From: Nick Howard
Sent: 27 June 2019 10:02
To: Amber Willard <Amber.Willard@arun.gov.uk>
Cc: Joanne Lewis <Joanne.Lewis@arun.gov.uk>
Subject: RE: fp/16/19/pl

I am the new officer on an application FP/16/19/PL at at 1 A Wood Hill Way, Felpham.

FLOOR PLAN

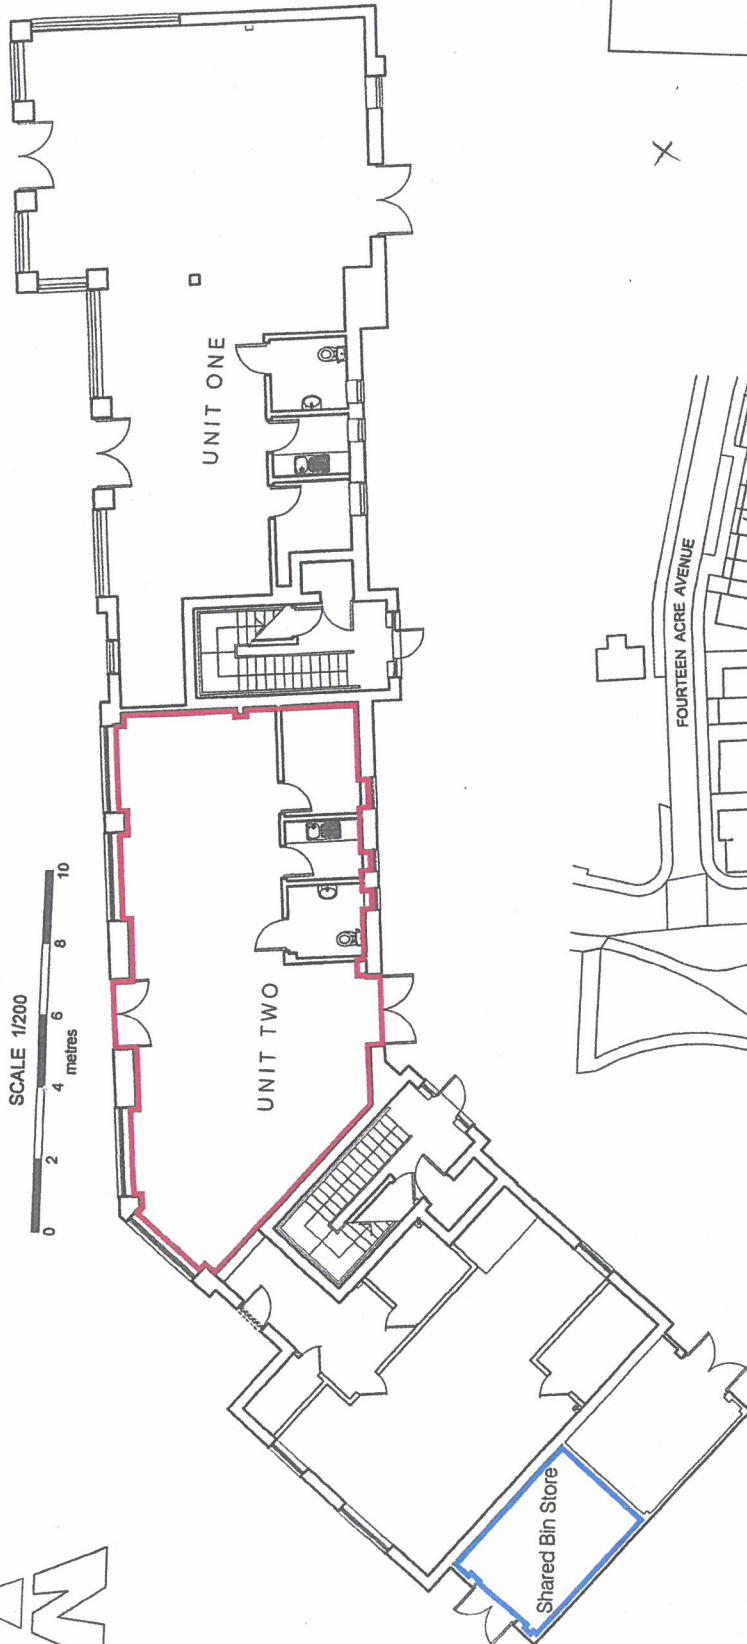
Sorry in the delay I am on short weeks over the coming month. Yes, I did meet with the owners of the new café recently (Wishfield Café) following requests for food advice visits. They are not intending to do any cooking but to use sandwich/Panini toasting machines and a microwave. They have installed a ceiling air conditioner unit and ceiling fans following my recommendation for the dishwasher and for the catering equipment previously mentioned only because of potential steam created. I am happy with the layout. Hope this information helps.
